About the application

Application number: 2023/92695	
What is the application for?:	Change of use and alterations to workshop to create two dwellings
Address of the site or building:	Crown Buildings, Scott Hill, Clayton West, Huddersfield, HD8 9PE
Postcode:

Client ACUMEN			
Project Land at Scott Hill, Clayton West			
Project No 2700	Drawing No 04	Rev	
Description Elevations & 3D as Proposed			
Scale 1 : 50 @ A1	Date Drawn 01.08.23	Drawn By AO	Authorised By JC
Purpose of Issue Planning ☒ Building Regs ☐ Tender ☐ Construction ☐ Comment ☐ Info ☐

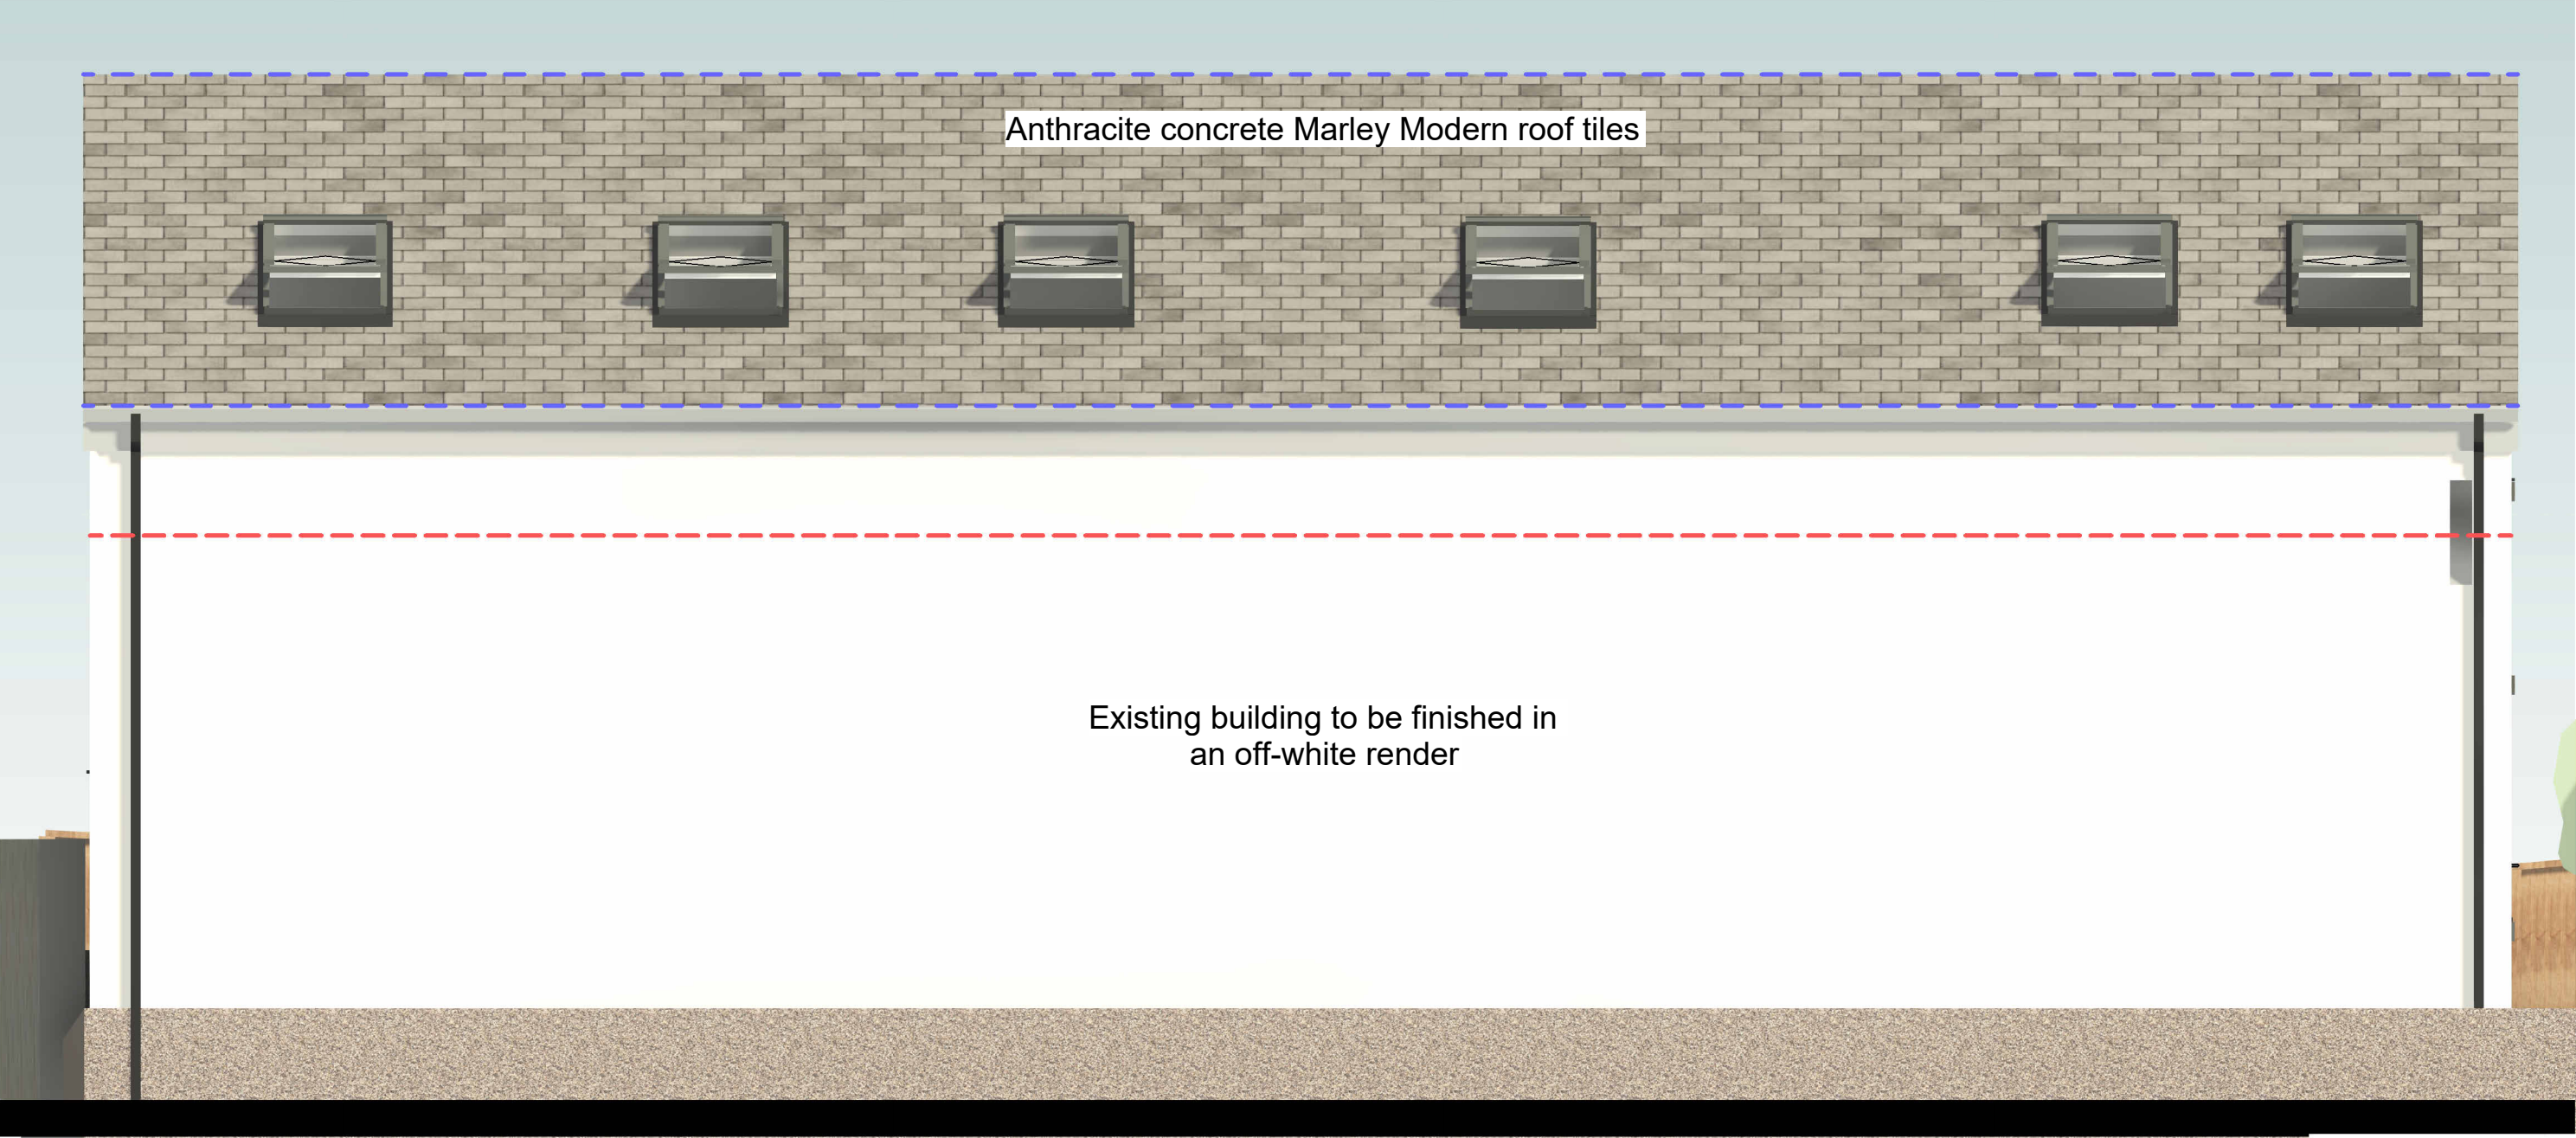
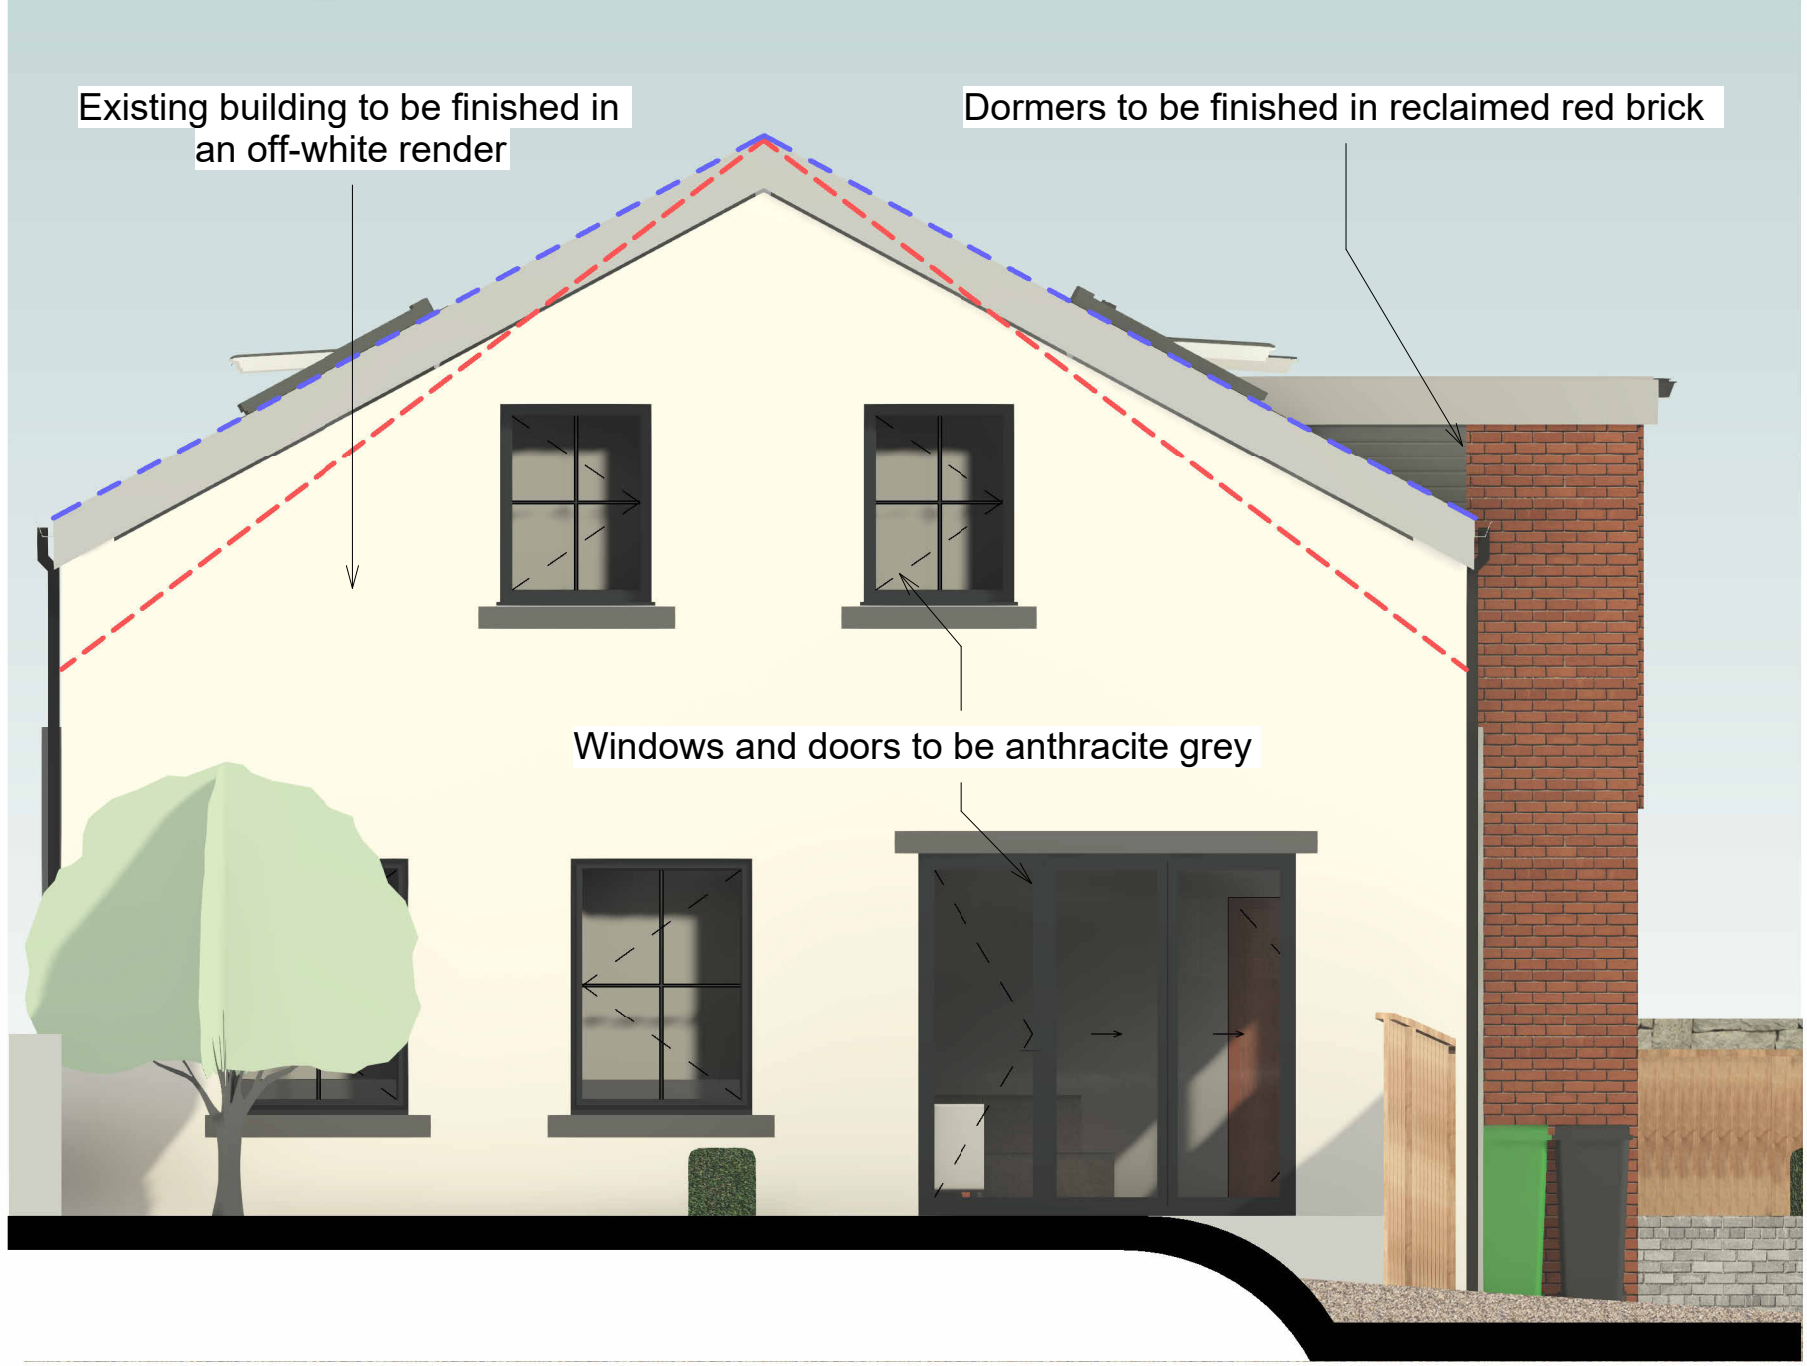
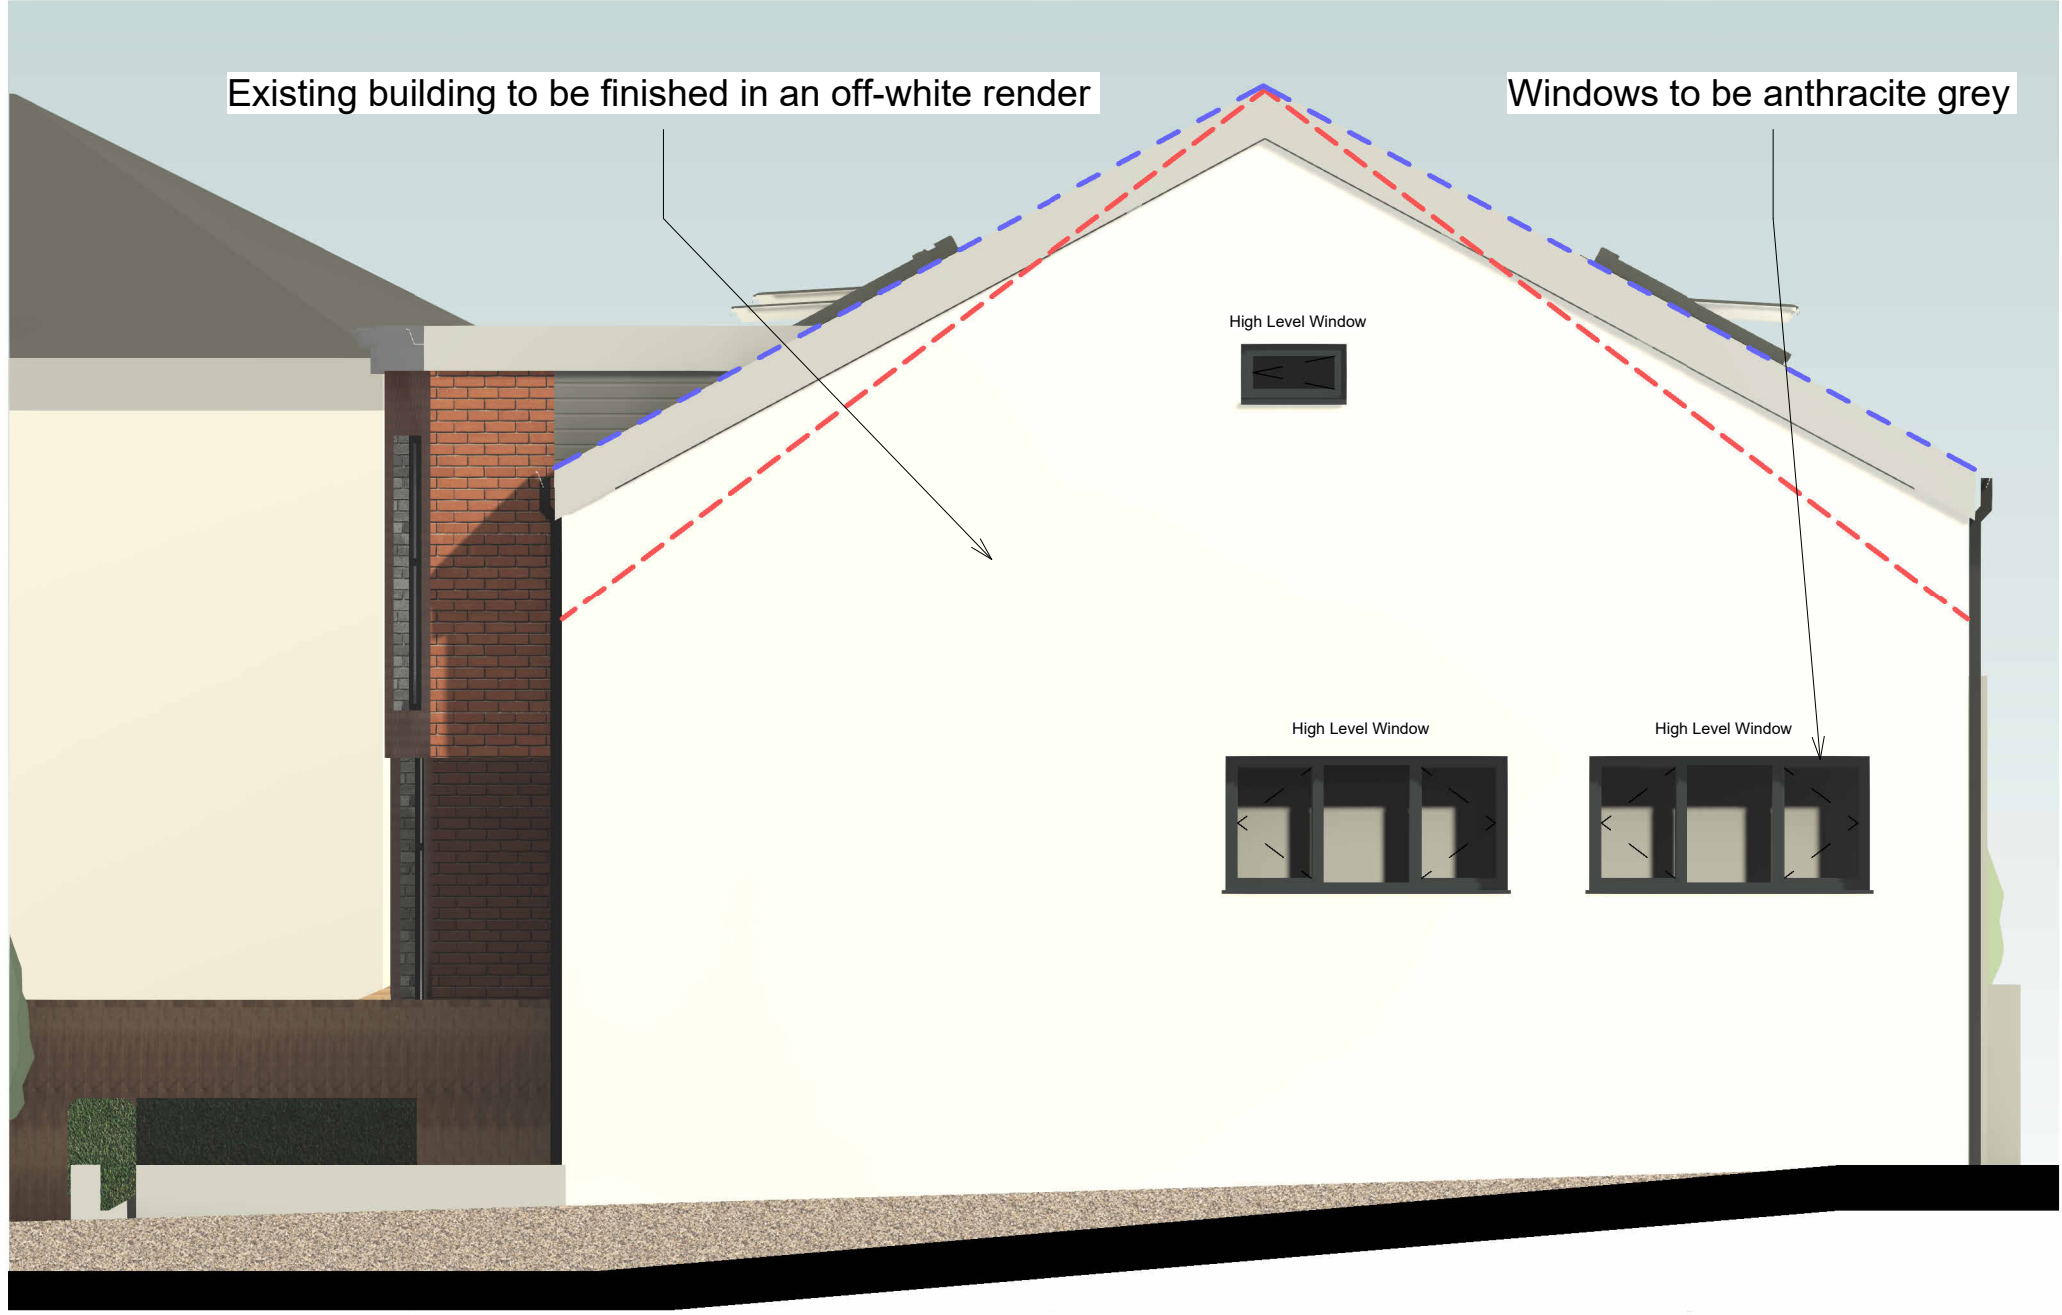
Type of comment: An objection	
Do you wish your comments to be published on the website anonymously?	Yes
I object to the planning application due to a loss of privacy as plans show non obscured glass windows overlook habitable rooms in my house and my garden. I object to the car parking area identified at the rear of the property. Highway safety on the blind bend at Scott Hill will be affected if cars cannot be manoeuvred to turn around and exit safely due to a lack of space and the area is reduced with proposed entrance door dormer columns protruding.
